Sterling Ranch Comment Response Letter

RE: Sterling Ranch Comments -PPR-19-030 Sterling Ranch Wastewater - CSU Line

Enclosed are the response to comments provided by El Paso County Development Services Department on the Sterling Ranch Project; PPR-19-030 Sterling Ranch Wastewater - CSU Line, Second Submittal

NOTE: THE CONTRACTOR WILL ENTER THE PROJECT SITE ADJACENT TO THE STERLING RANCH LIFT STATION (SEE ABOVE). DAILY ACCESS FROM EXISTING COWPOKE DRIVE IS NOT PERMITTED. NO ALTERNATIVE ACCESS FOR THIS PROJECT IS PERMITTED.

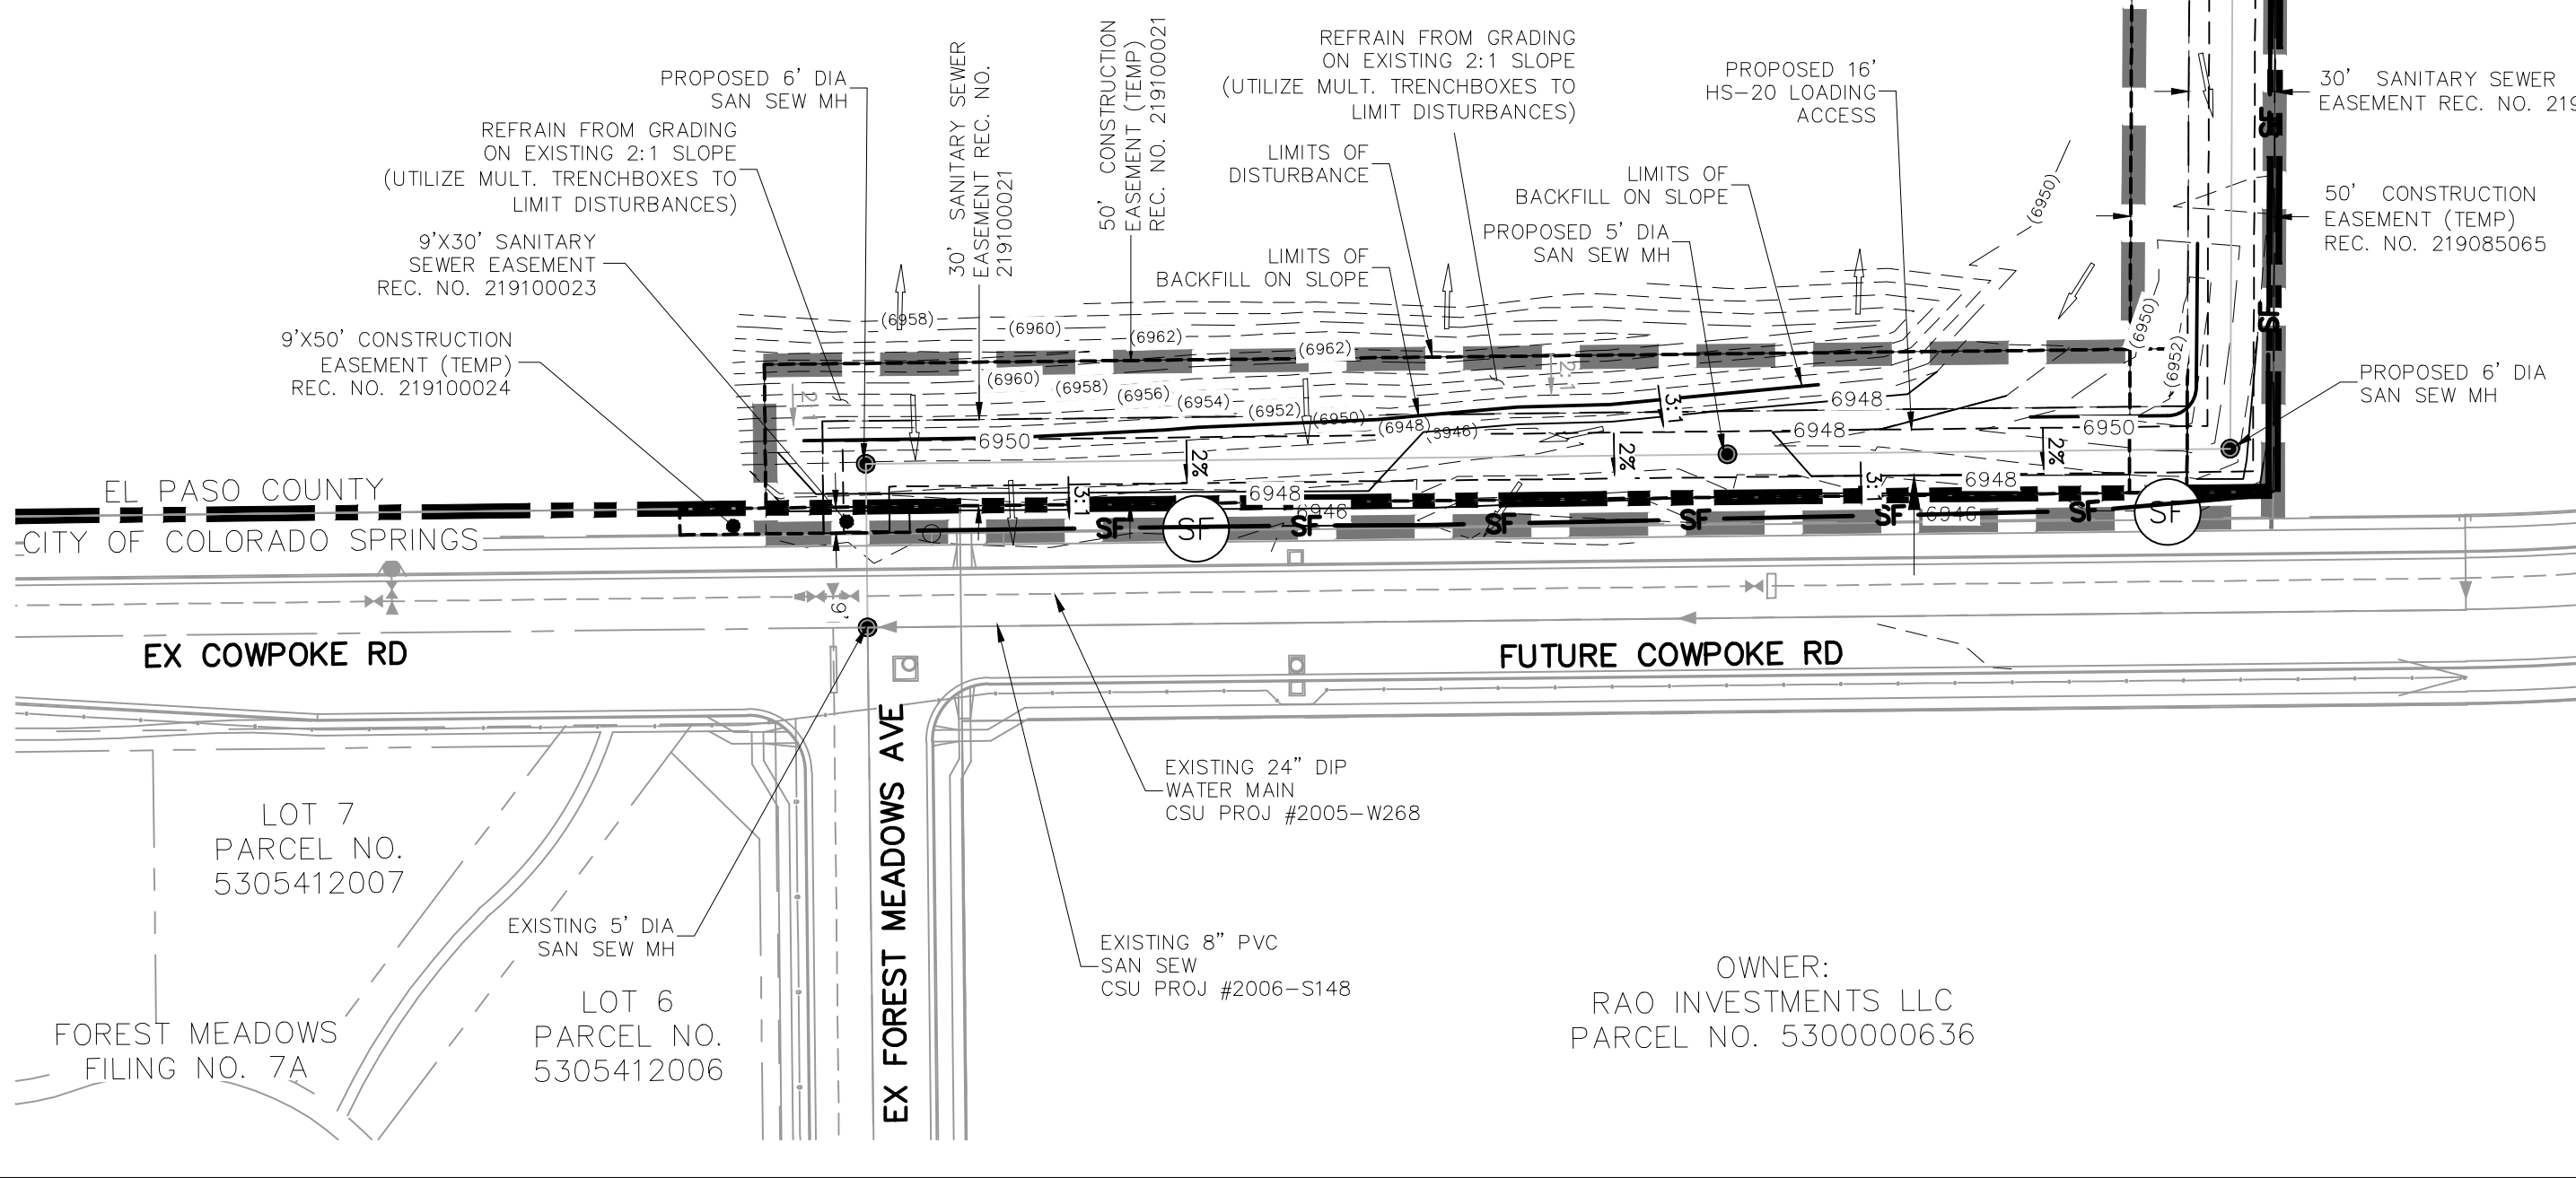
1. It appears that this project will disturb greater than one acre, and even if this sewer line construction does not in itself, it would be determined to be part of a larger common plan of development under the County's updated MS4 and ECM provisions. Provide a GEC Plan; this can be included in the CD set. **A GEC has been submitted.**
2. Ensure that all GEC Plan and SWMP checklist items are provided. GEC and SWMP checklists will be reviewed in detail with the next submittal. For any unknown/undetermined items, add a note to the GEC Plan stating how they will be addressed. **A SWMP has been submitted.**
3. Provide the updated ESQCP permit. **The ESQCP has been submitted.**
